PLANNING AMENDMENT

Application No. H17/0021/01/A2

Description: Conversion of methodist church
to dwelling

**Conversion of Methodist Church to dwelling at
Station Road, Surfleet, Spalding, Lincs
Reference No: H17/0021/01**

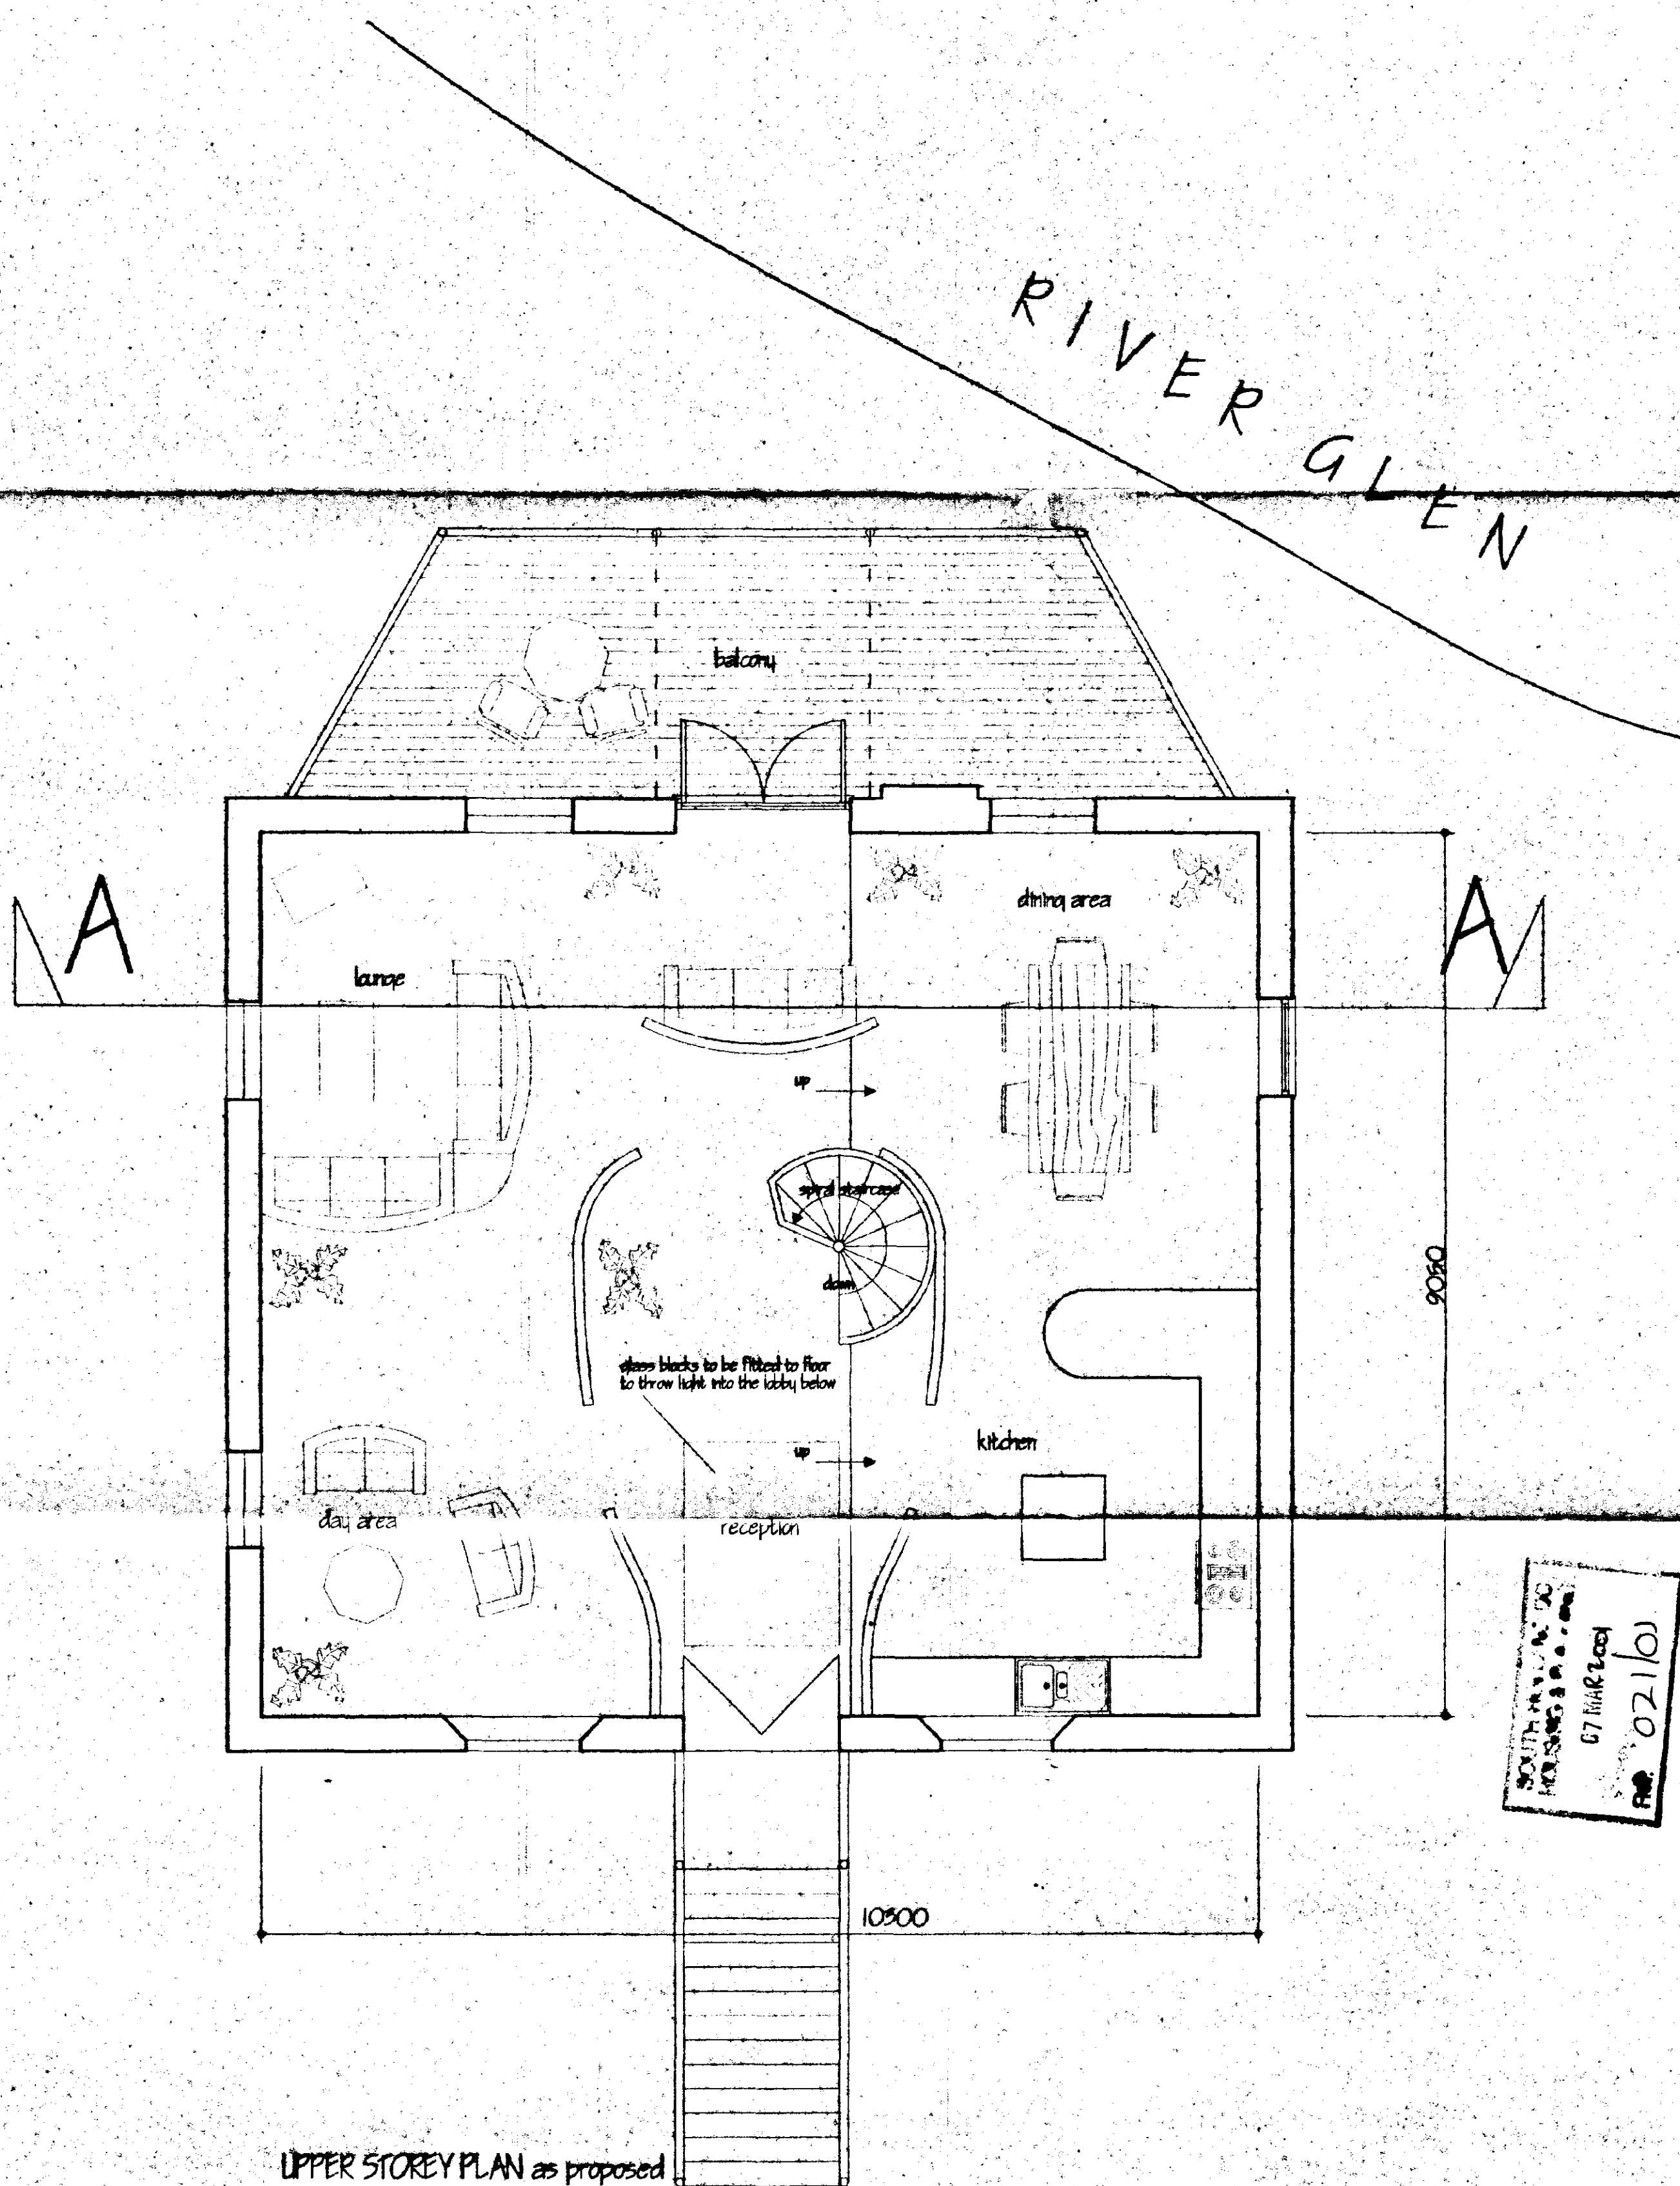
1. Drawing 138/00-05 shows the existing floor raised by approx 200mm, which goes against condition 3 of the planning approval. New drawing 14250-14B shows the floor finishes being raised by approx 75mm to incorporate a new underfloor heating system, resulting in a cill level of 1967mm to windows overlooking the garden of 53 Station Road. *original drawings 138/00-05*
2. The cill height to new window to dining area (south west elevation) has been reduced to 1000mm. *needs PP.*

Drawing No.
 02

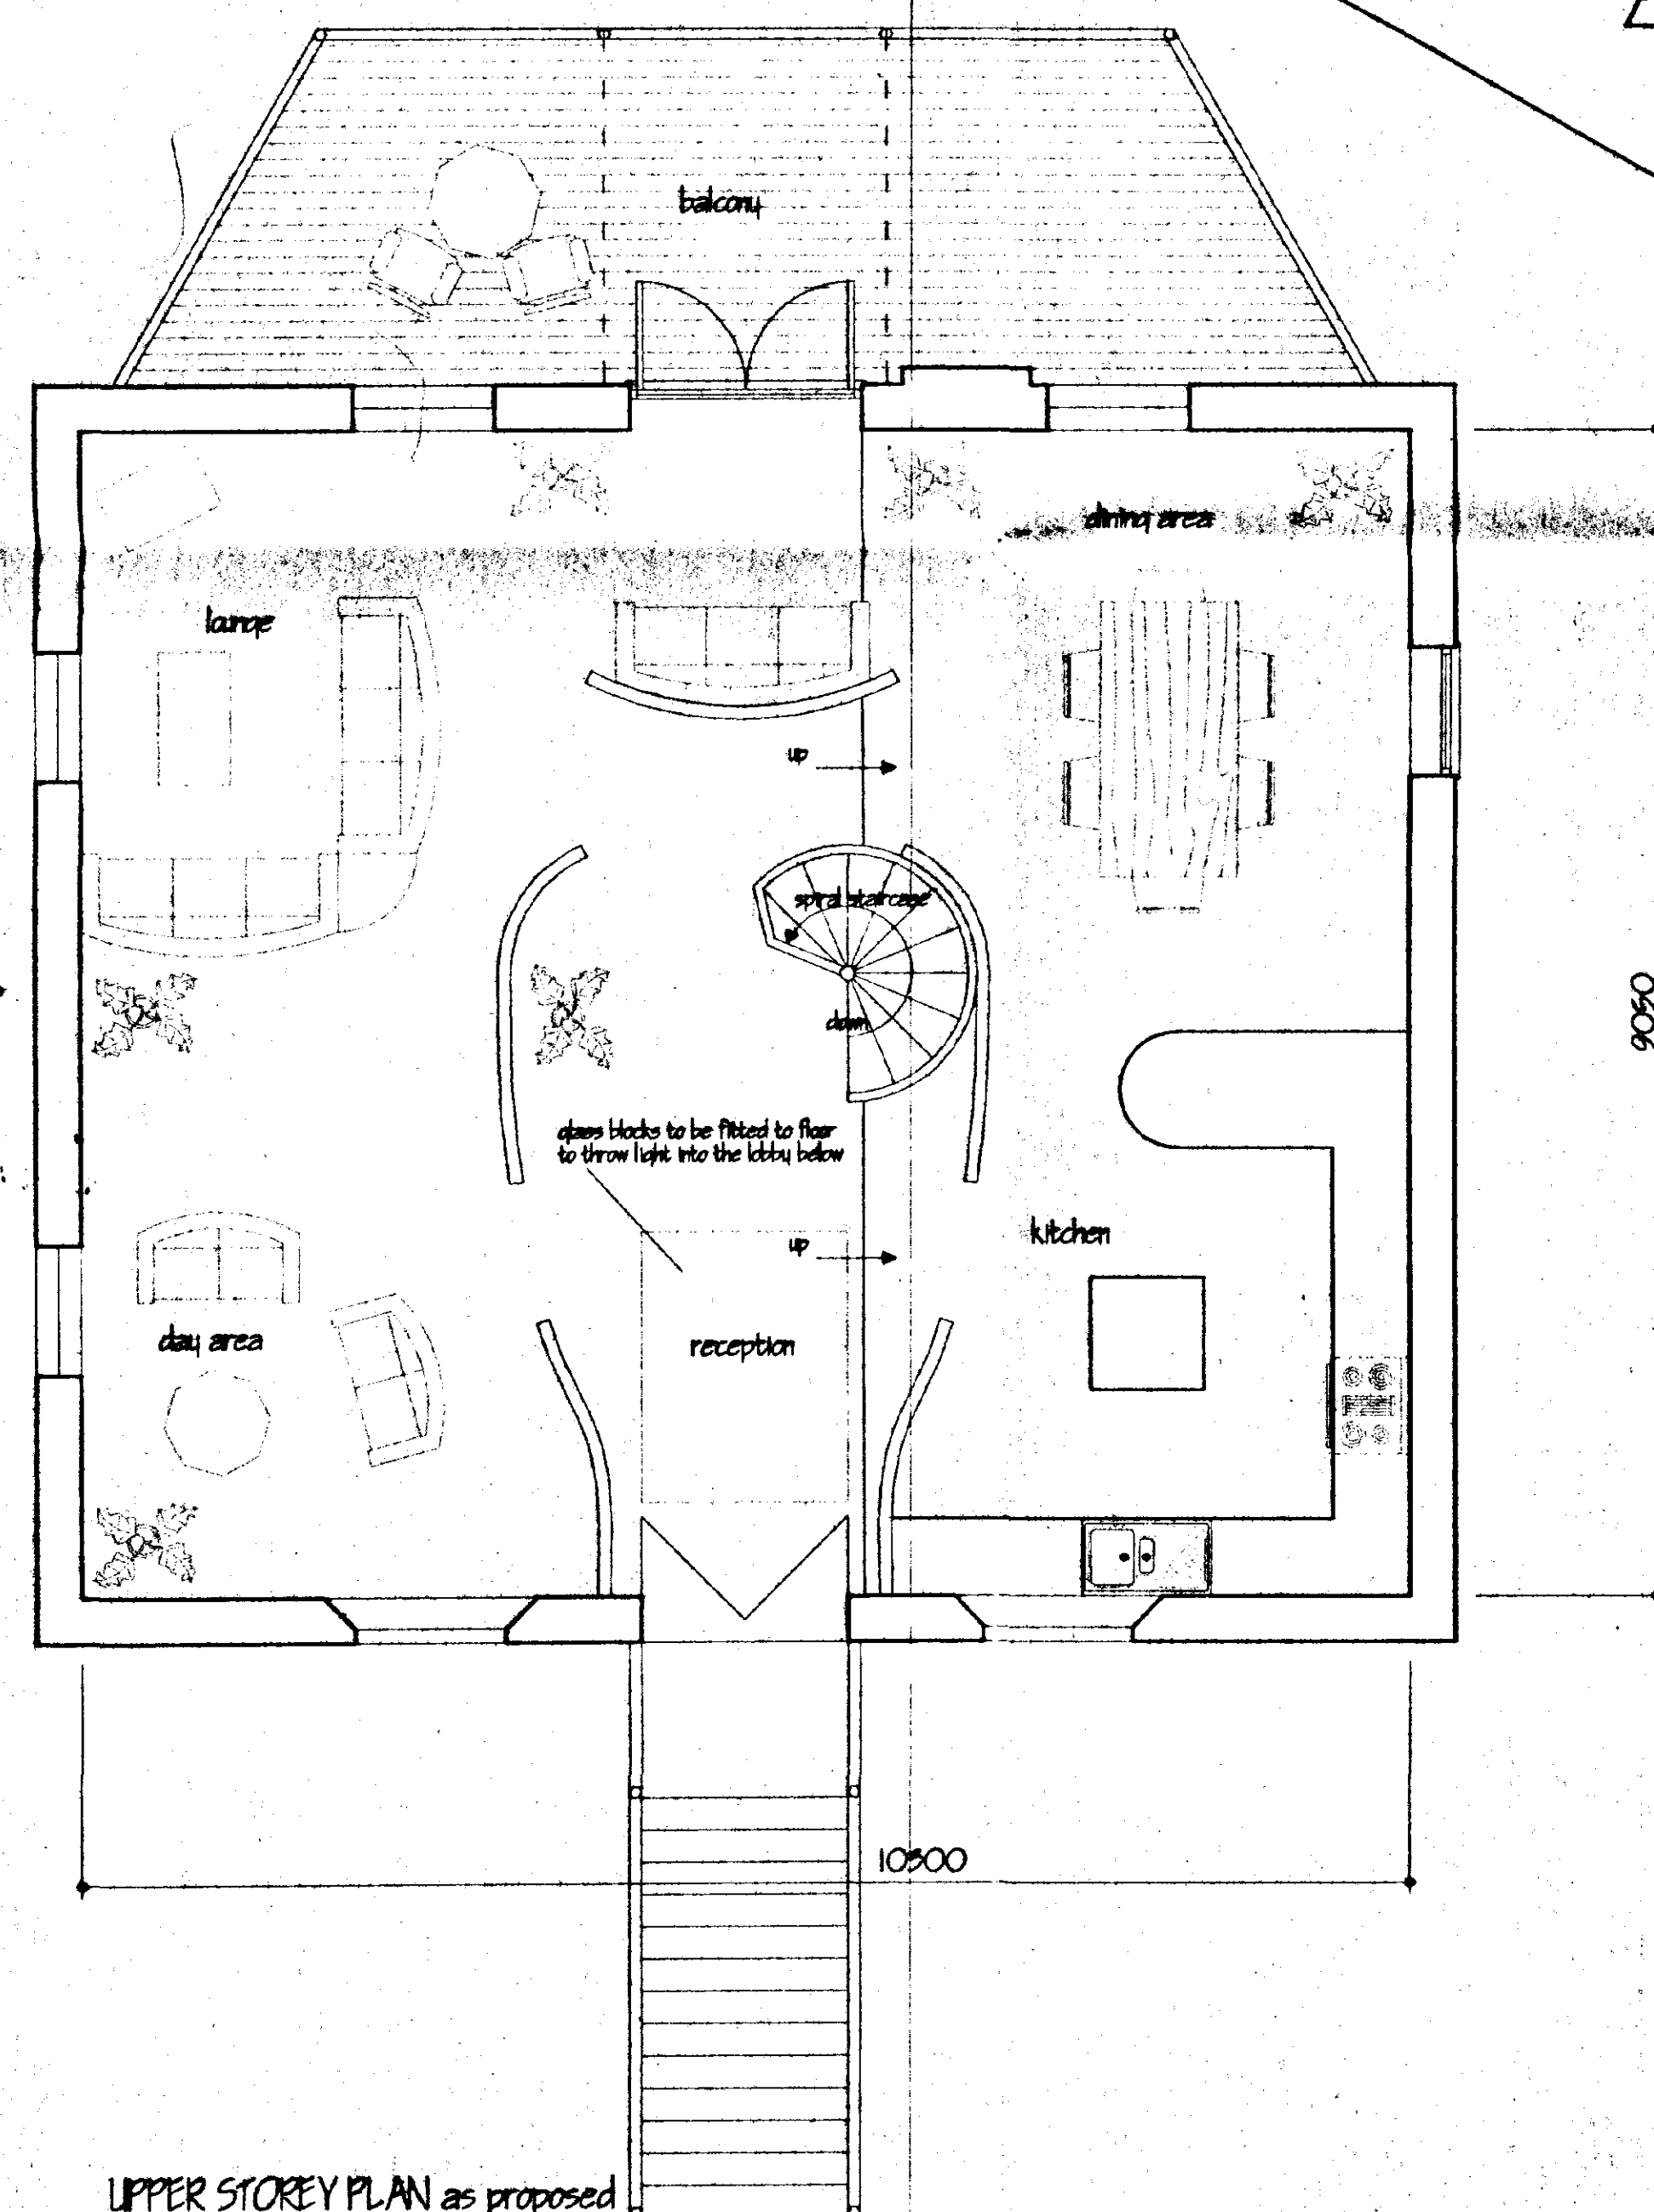
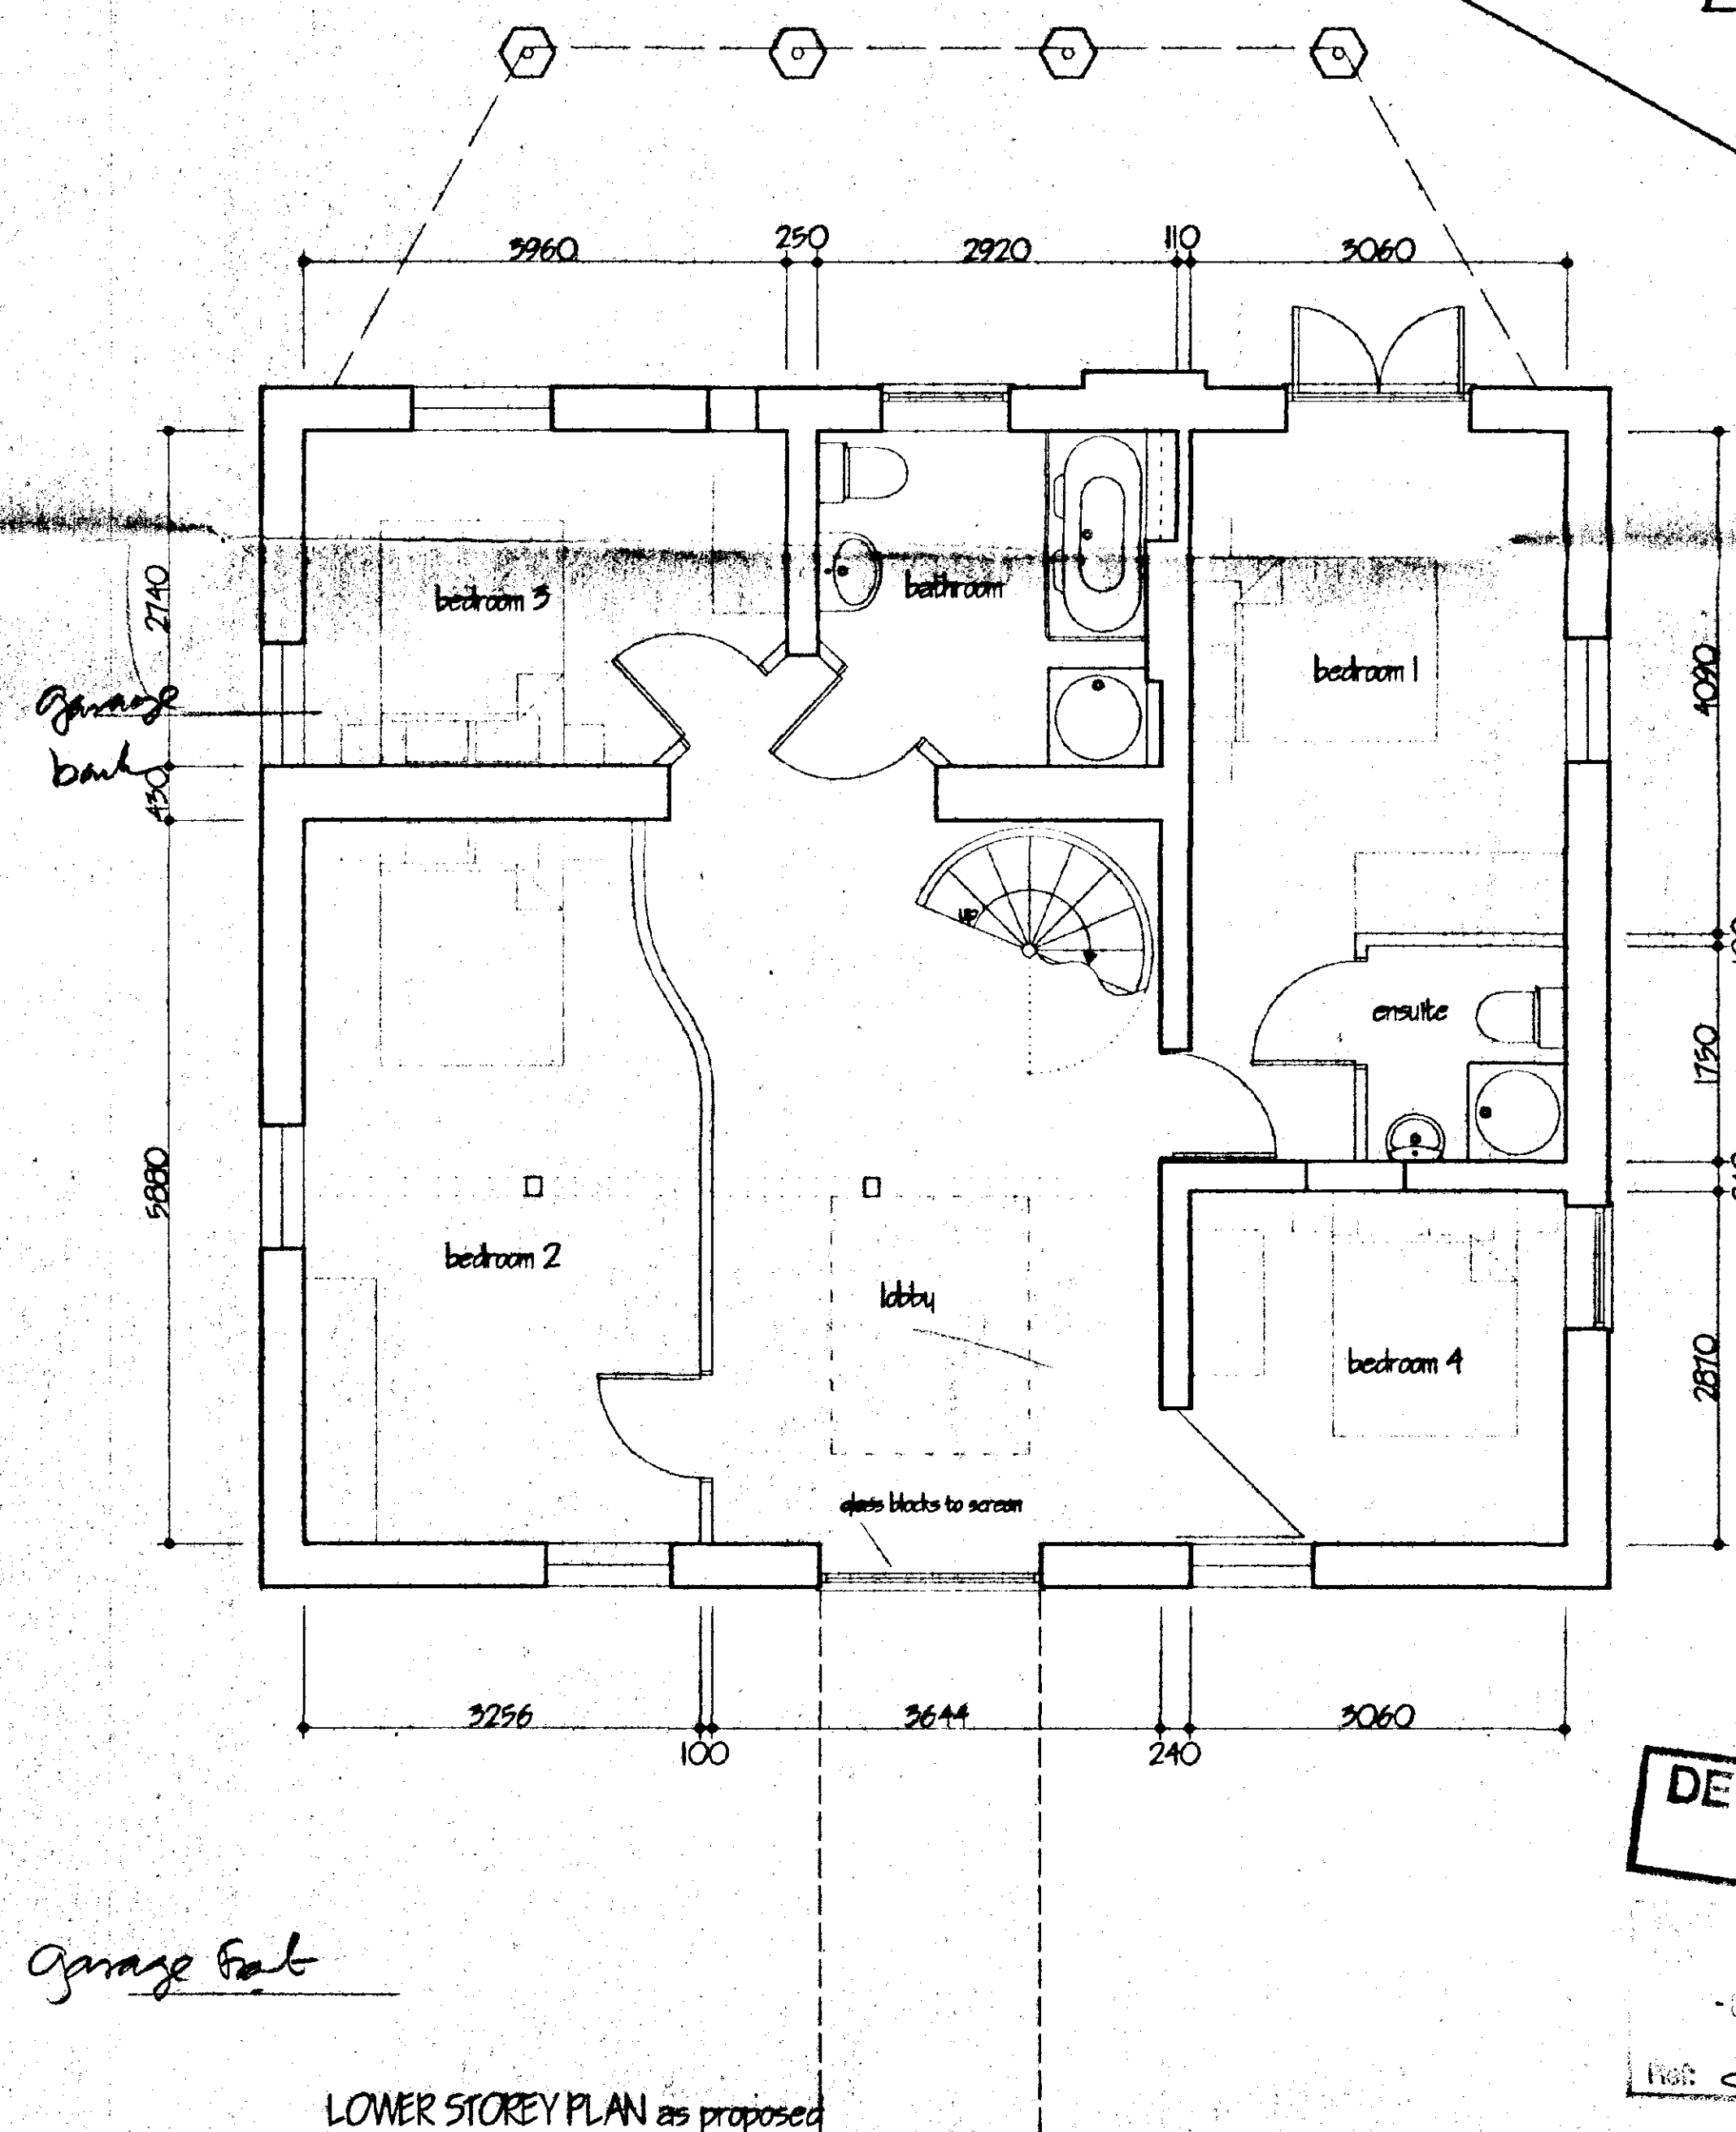
- 1) The balcony design, which will be submitted as a Condition Compliance.
- 2) The change to the cill height of the new window to the dining area. Such a change is contrary to Condition 9 and therefore Planning Permission is required. The window as shown on the scheme prepared by G.R. Merchant on drawing number 138/00/02, can be installed in accordance with the Planning Permission.
